Please ask for: Ms Iqraa Malik
Email: iqraa.malik@terraquest.co.uk
Telephone: 01212341390
Our Ref: AB/110/20/HH
Your Ref:
Date: 19th October 2020

Application for Planning Permission for Works or Extension to a Dwelling

Development: Proposed conservatory to side elevation
Location: 42 Dalloway Road Arundel BN18 9HW

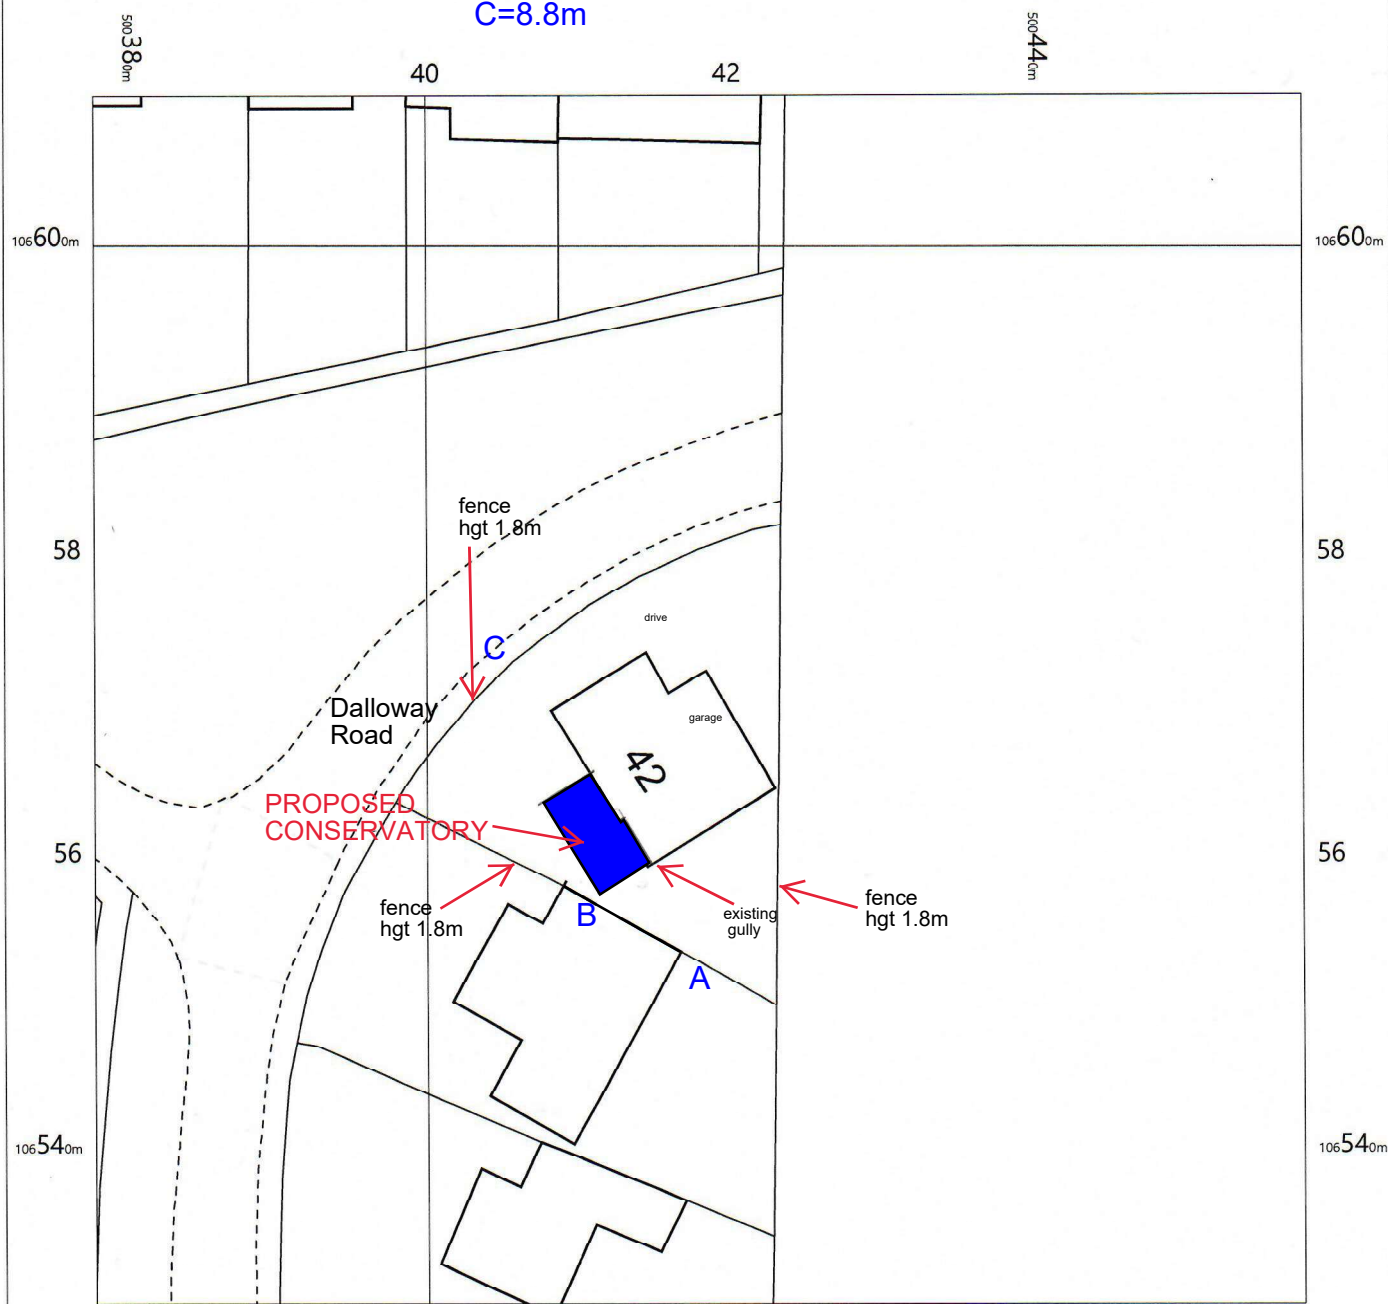
Block Plan: You are required to submit dimensions on the block plan from the proposed extension to all site boundaries.
